Application No: AB/19/21/HH
Site Address: 32 Maltravers Street Arundel BN18 9BU
Description of works: Erection and replacement, with new, of an original chimney, the existing rear single storey extension, the external steel staircase and bridge, french windows, and new brickwork to the existing Twitten window, plus roof light, roof tiles and dormer lead cladding to the rear main roof. This application may affect the character and appearance of the Arundel Conservation Area.

Thank you for your internet representation made on 31st March 2021 which has been recorded as no objection with the comments as follows:

project:	32 Maltravers Street - Arundel - BN18 9BU		
drawing title:	Existing and Proposed Site & Roof Plans		
drawing status:	Planning Application Proposals		
date:	18 - 02 - 2021	scale at A3 original size	1: 200
no:	JW2012ARU - PL03	rev:	B

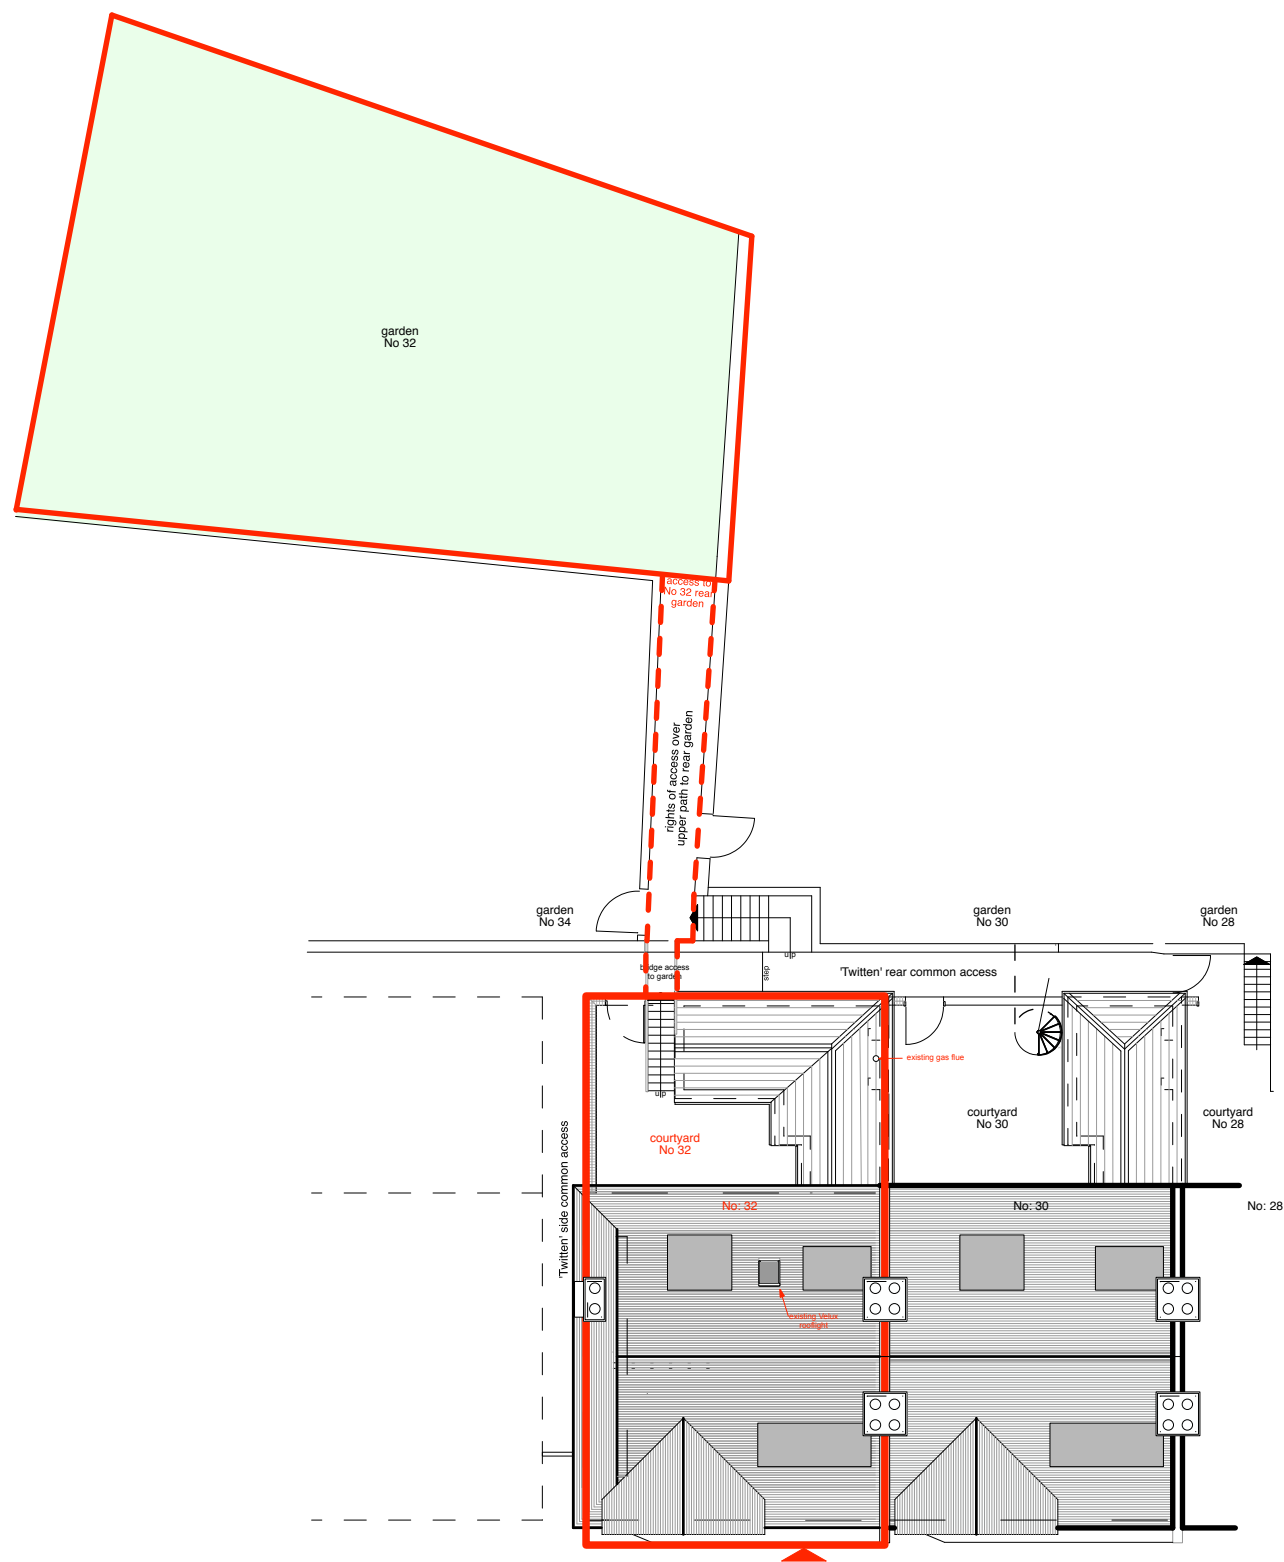
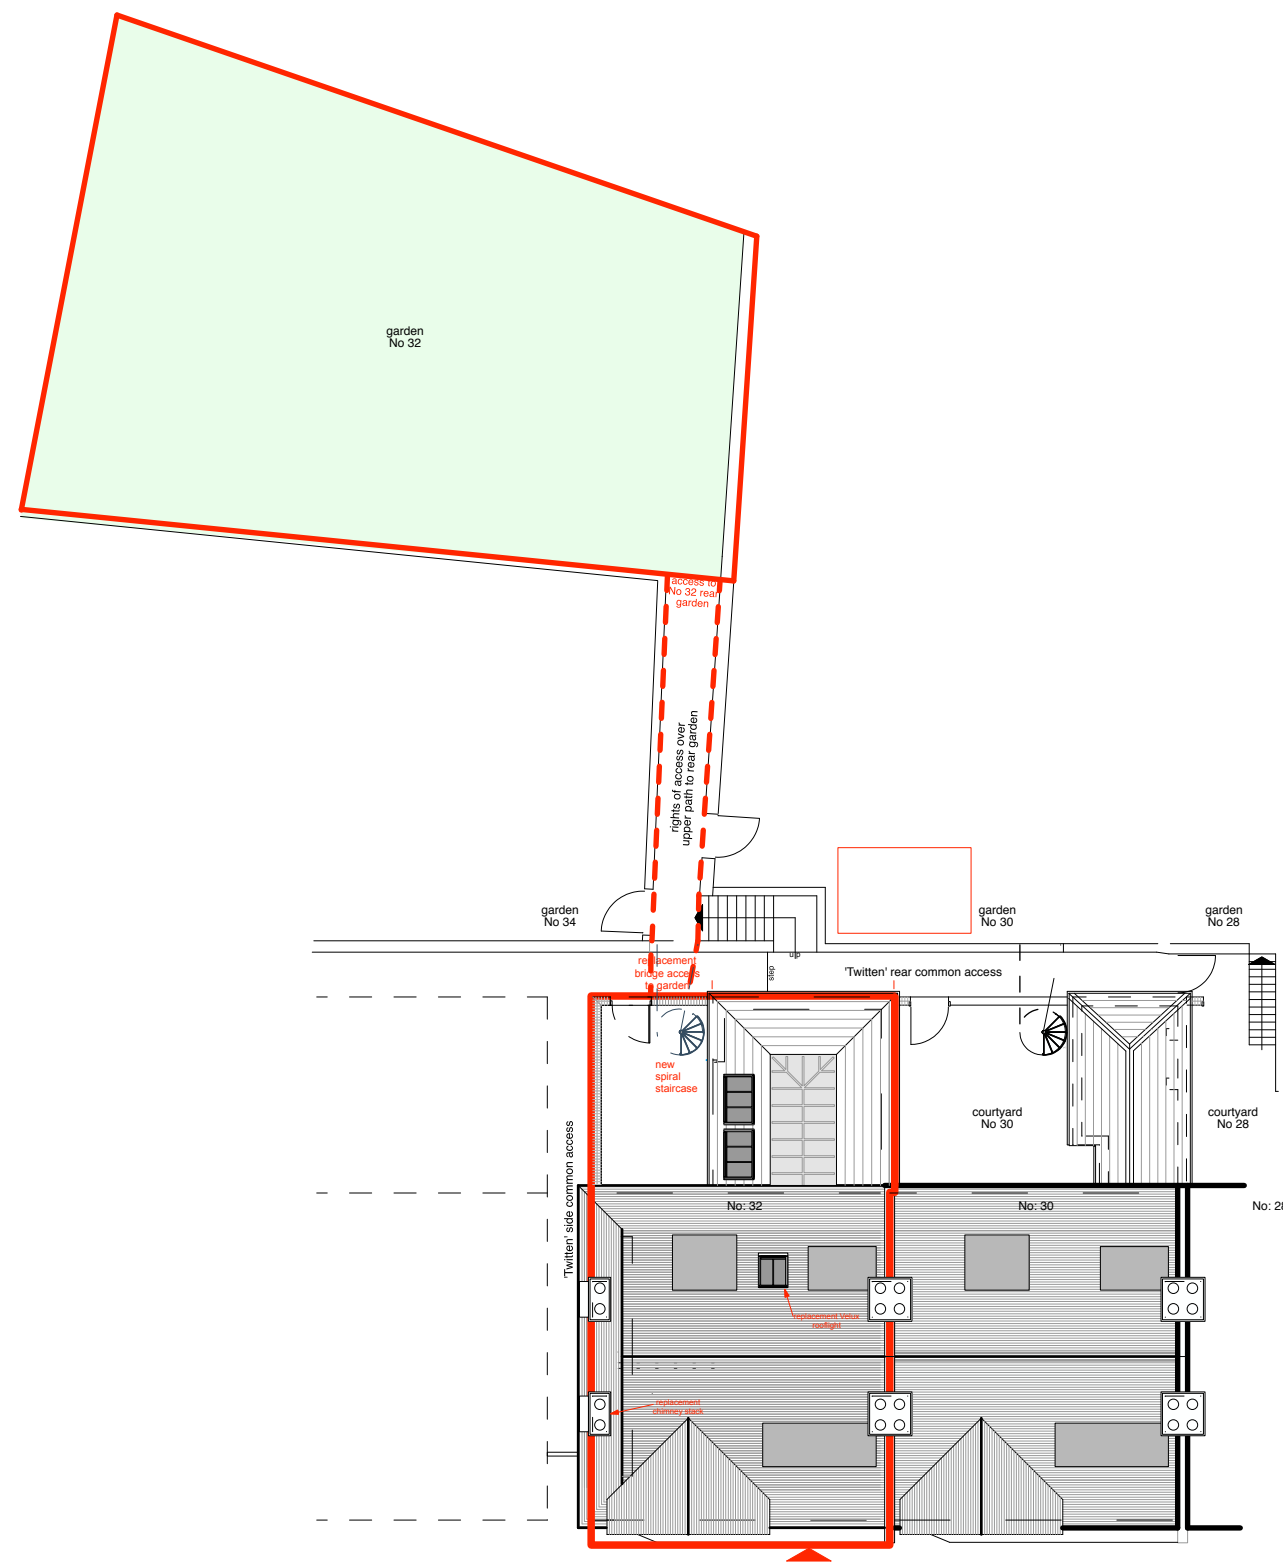
The Committee have no objection to the Application provided that the new tiles match the existing ones.
